# CITY OF ALBUQUERQUE

**Re: Laundromat TI**  
**12910 Indian School Rd NE**  
**30-Day Temporary Certificate of Occupancy**  
**Transportation Development Final Inspection**  
Engineer's/Architect's Stamp dated 8-27-20 (J22D052)  
Certification dated 5-11-21

TCL PLAN

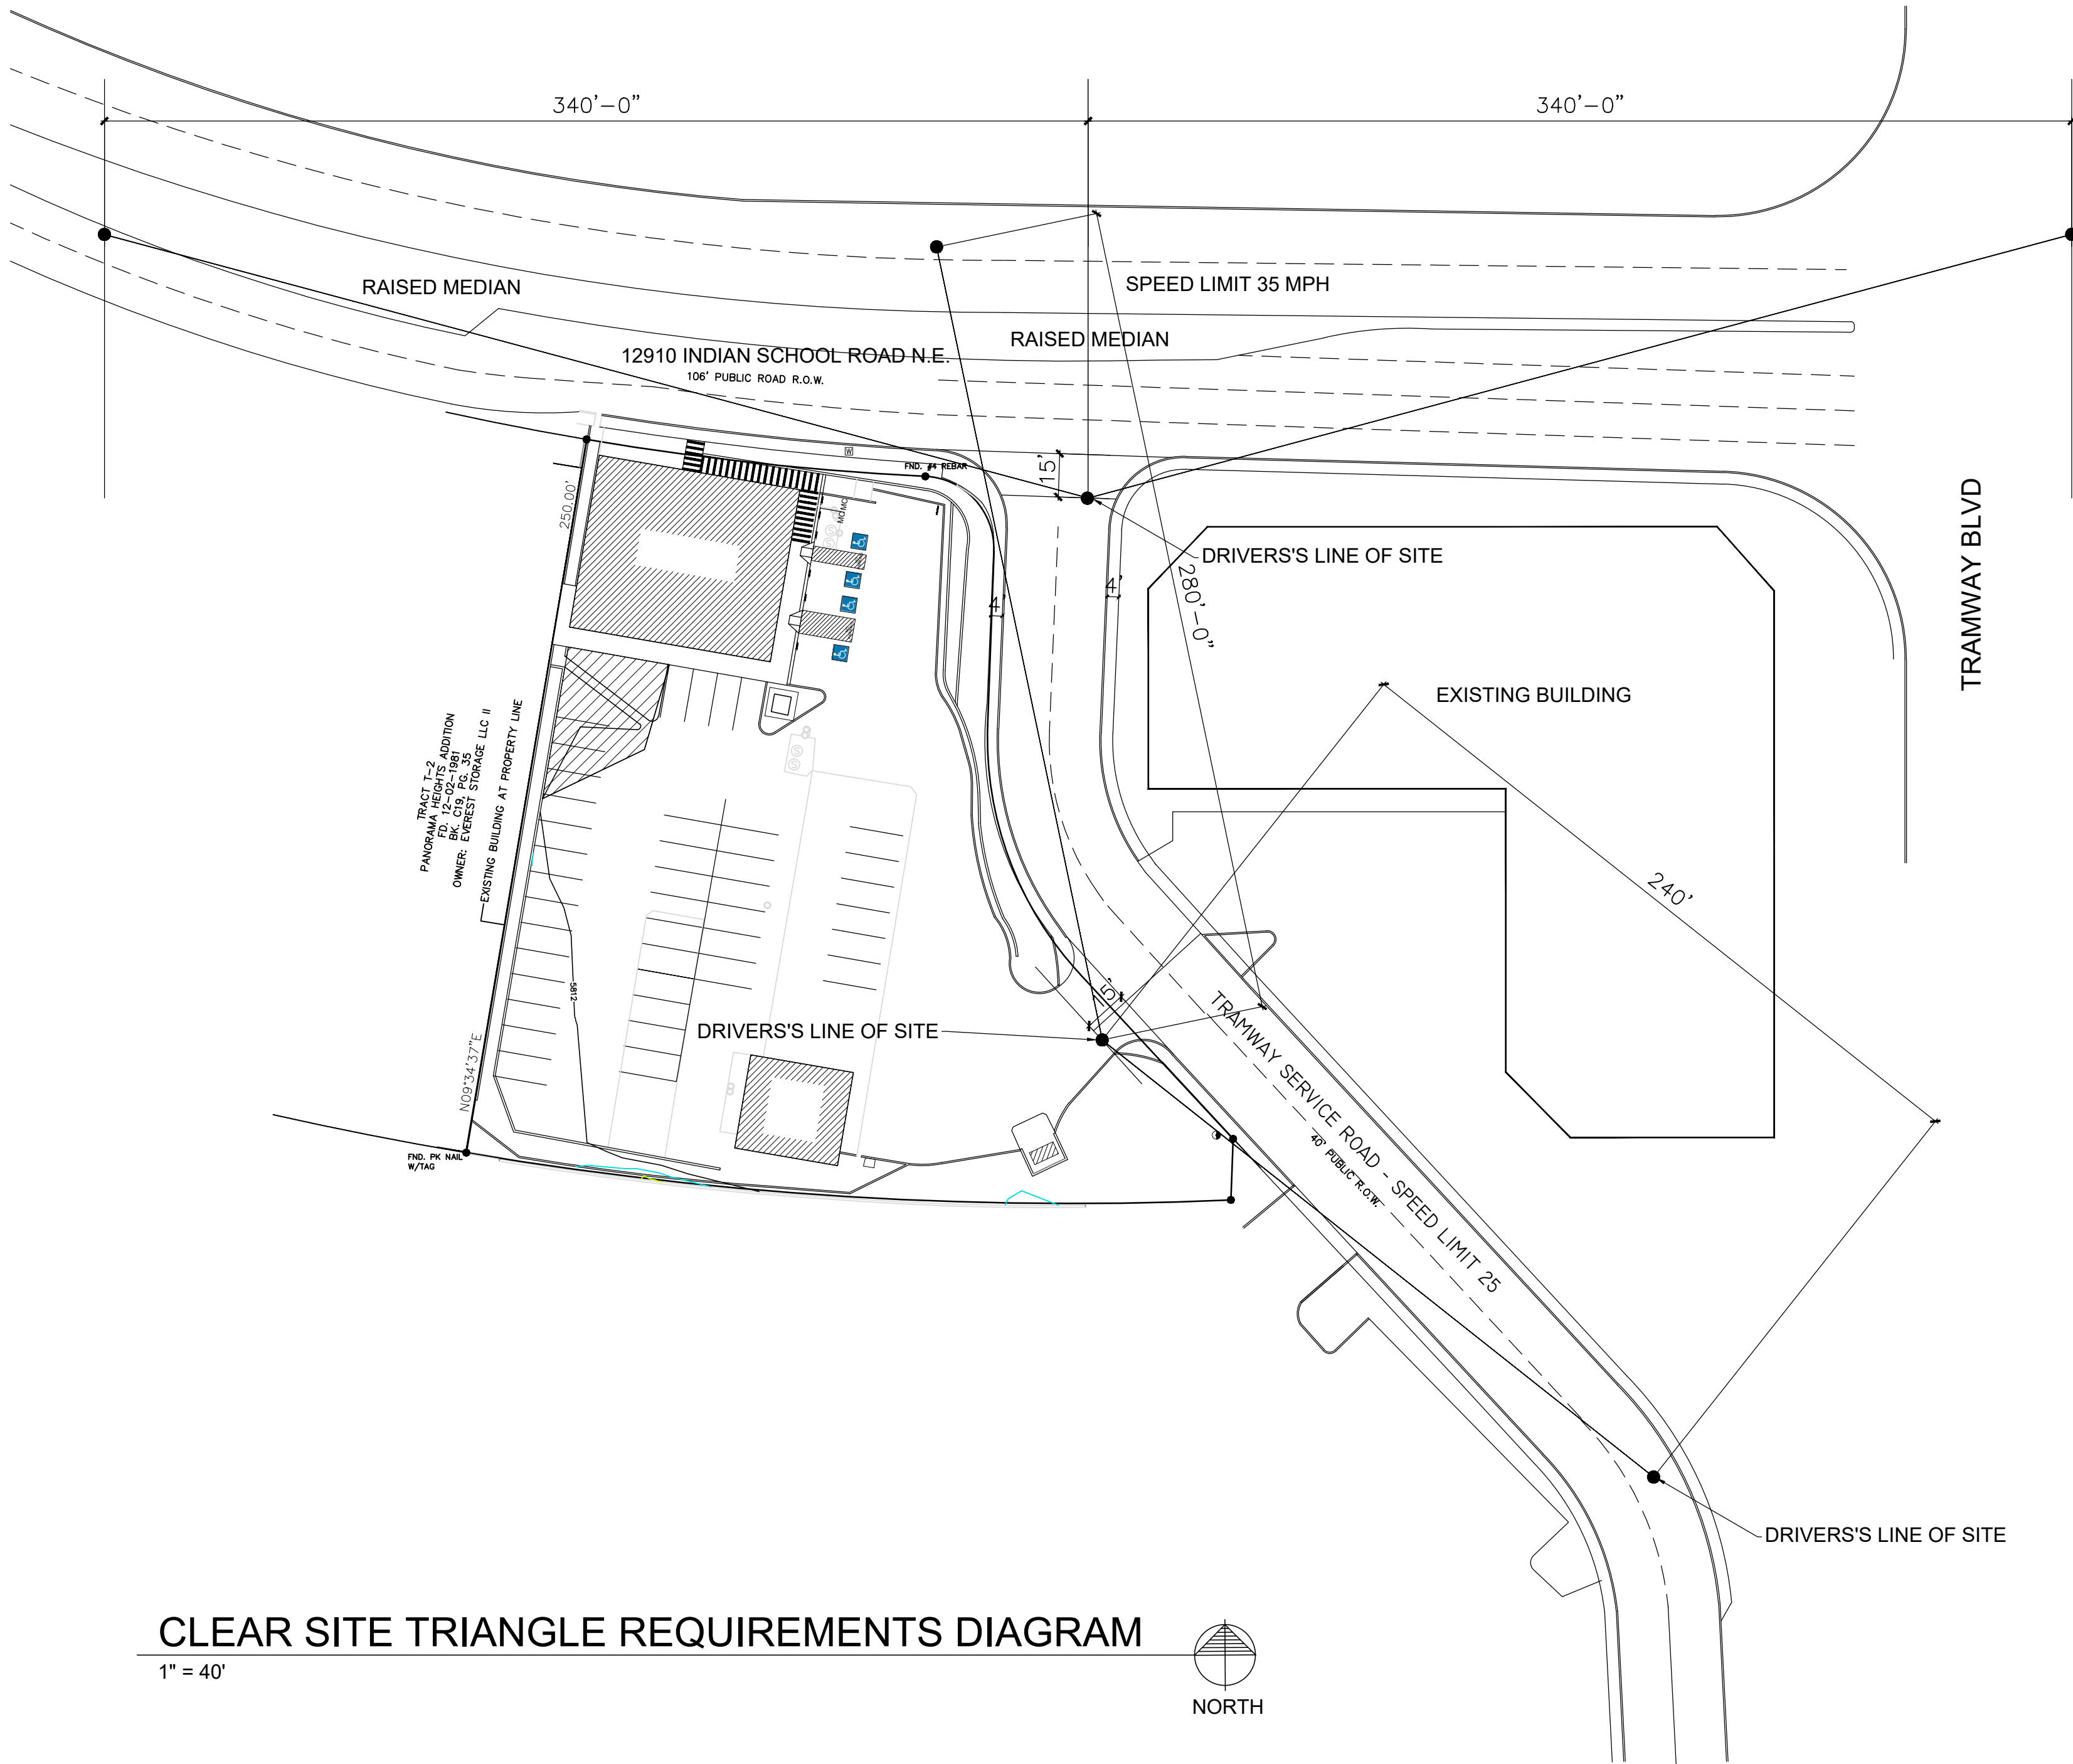
- ADA pathway from public sidewalk to building entrance is not ADA compliant. Please correct. (See attached Photo)

1. The approved and stamped TCL, with changes drawn in red.
2. Transportation Certification letter on either the plan or applicants letterhead.
3. A Drainage Transportation Information Sheet (DTIS)
4. Send an electronic copy of your submittal to [PLNDRS@cabq.gov](mailto:PLNDRS@cabq.gov).
5. The \$75 re-submittal fee for log in and evaluation by Transportation.
